**Planning & Building Control Service
Development Management
Westgate Plaza
PO Box 603, Barnsley, S70 9FE
Head of Service: Joe Jenkinson**

Our ref 2017/1116 & 2022/ENQ/00214

APPLICATION FOR NON-MATERIAL AMENDMENT to Planning Permission
2017/1116

Site Address: Land at the end of Tower Street, Barnsley, S70 1QS

Hadfield Developments	
Tower Street, Barnsley	
House Type Plans and Section	
Project number	17-185-
Date	31/07/2017
Drawn by	MC
Checked by	Checker
P01	
Scale	1 : 50

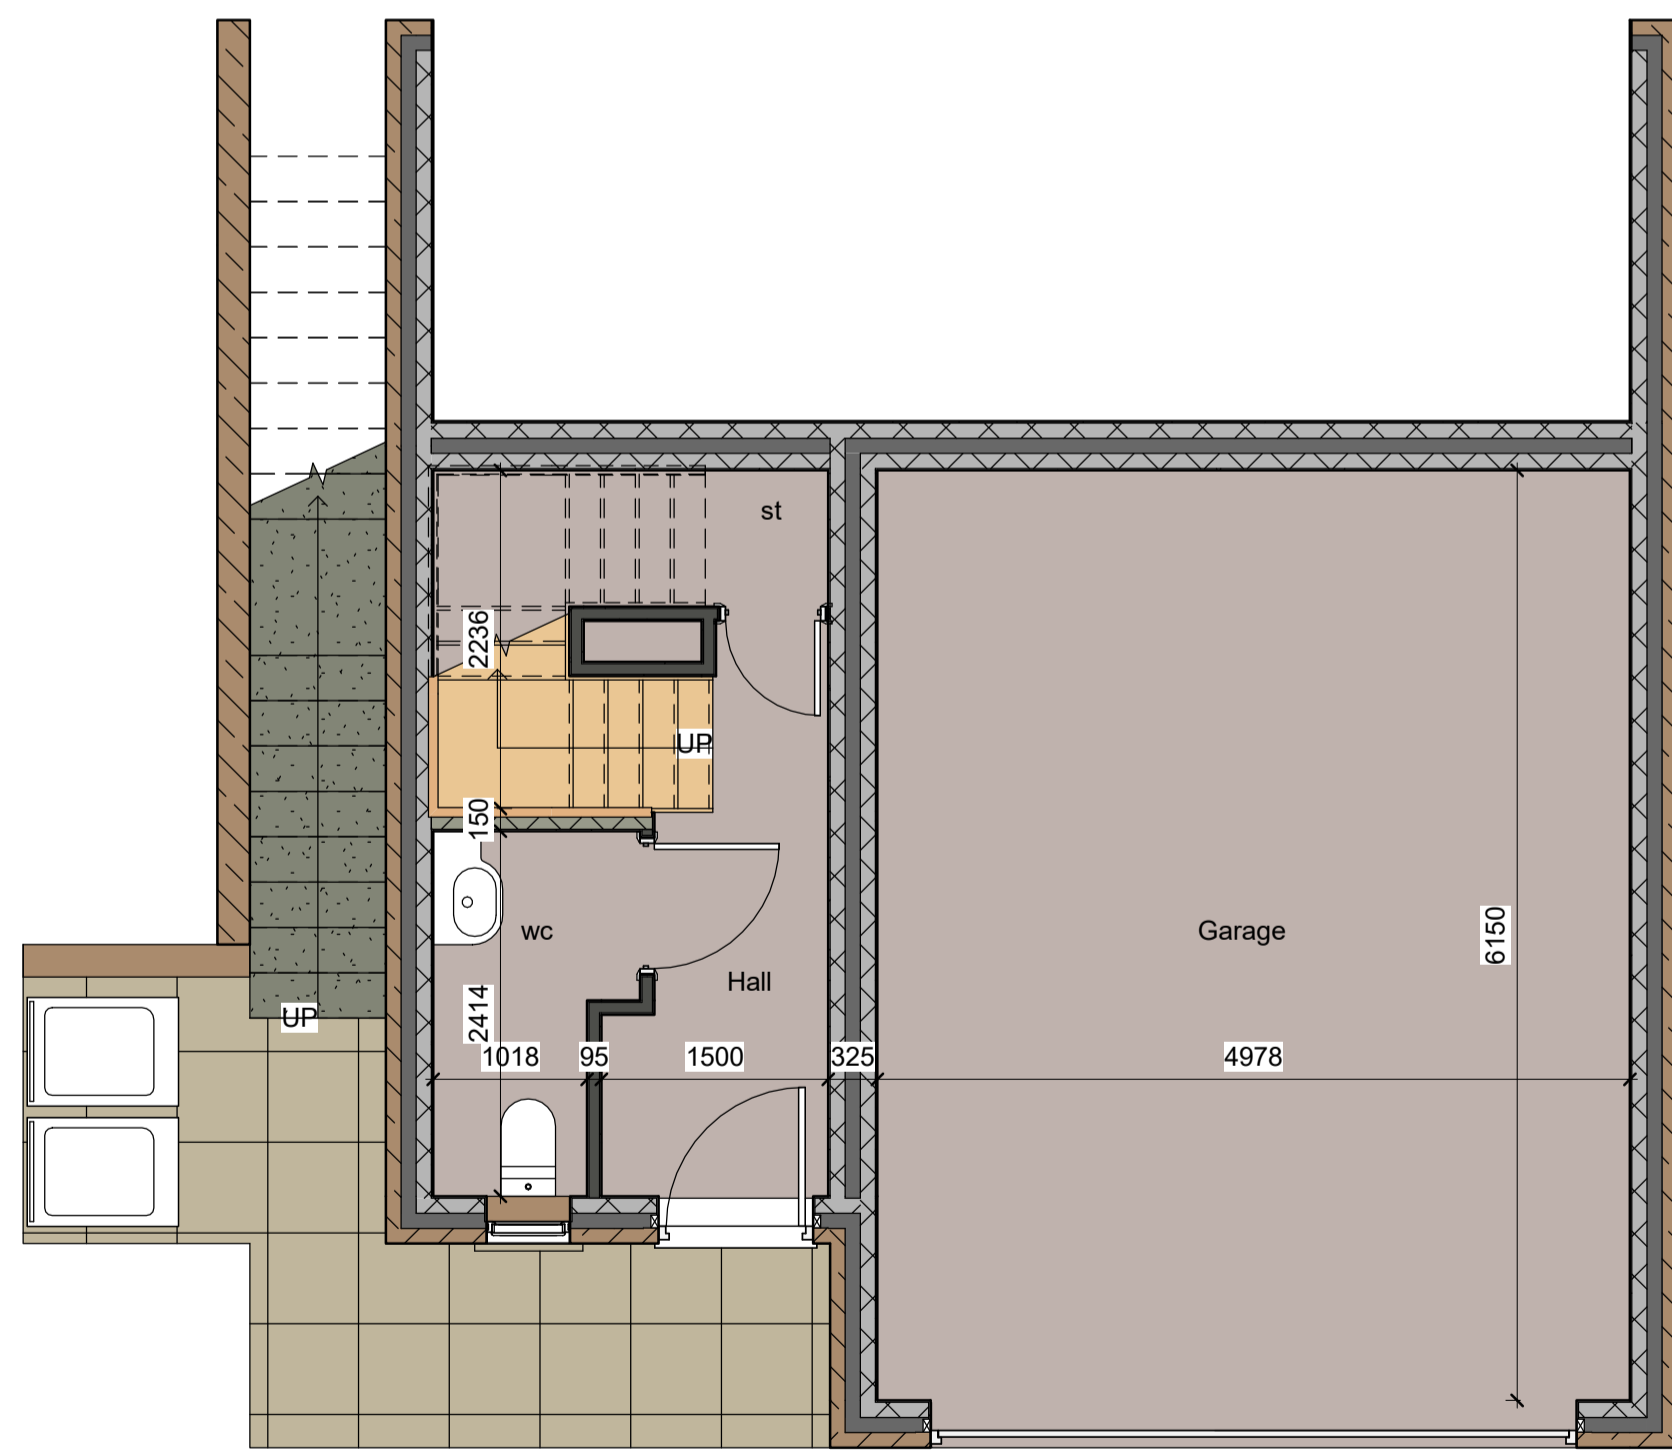
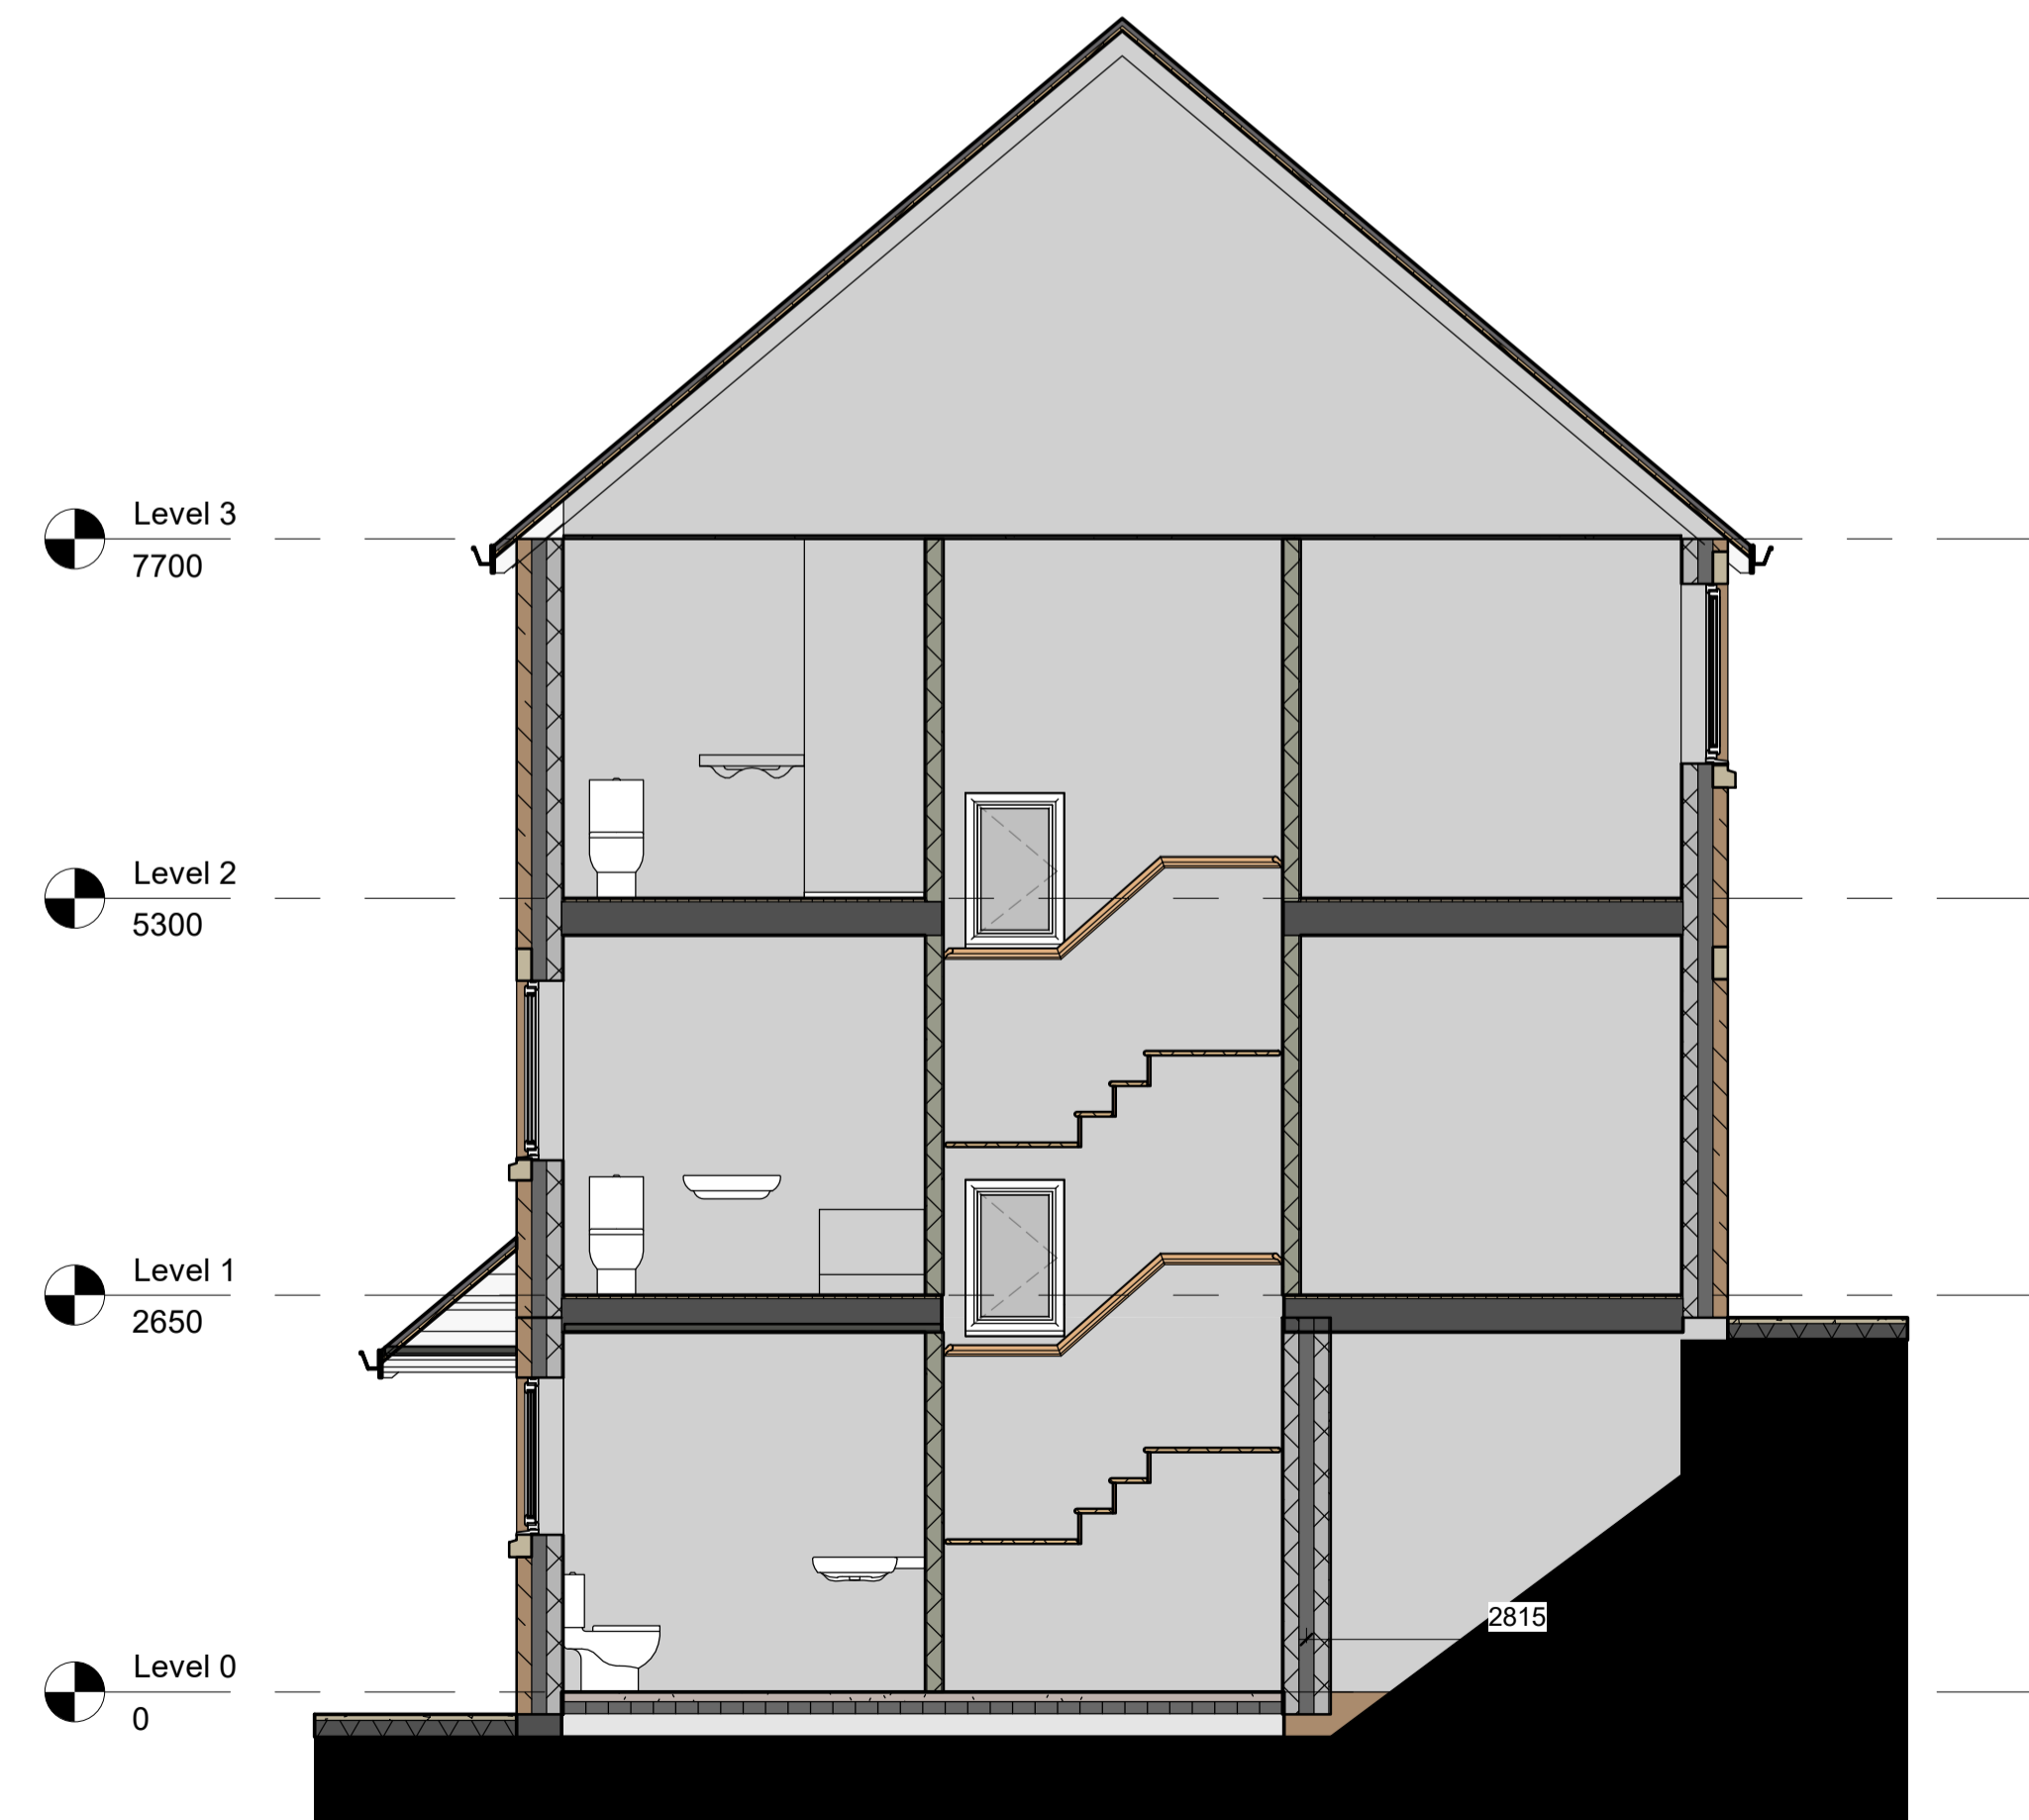
The changes proposed by the Non- Material Amendment are to submit amended plans which show Plot 5 to be handed opposite to the approved plans granted on 21st November 2017.

The reason for the proposed changes is that the developer has constructed the dwelling on Plot 5 handed opposite to the approved plan. That is, the approved plan shows a gable element containing the integral garage to be on the left hand side of the dwelling when viewed from the front elevation. However, on inspection, the dwelling has been constructed with this gable element and integral garage to the right side when viewed from the front elevation.

It is therefore proposed to substitute amended plan and elevations of Plot 5, together with an amended layout plan which accurately shows how Plot 5 has been constructed in order to bring the changes under planning control.

17-185 P01 House Type Plan and Section dated 13/07/22
17-185 P02 Plot 5 Elevation as built dated 13/07/2022
17-185 P03A Site Layout as built dated 15/07/22
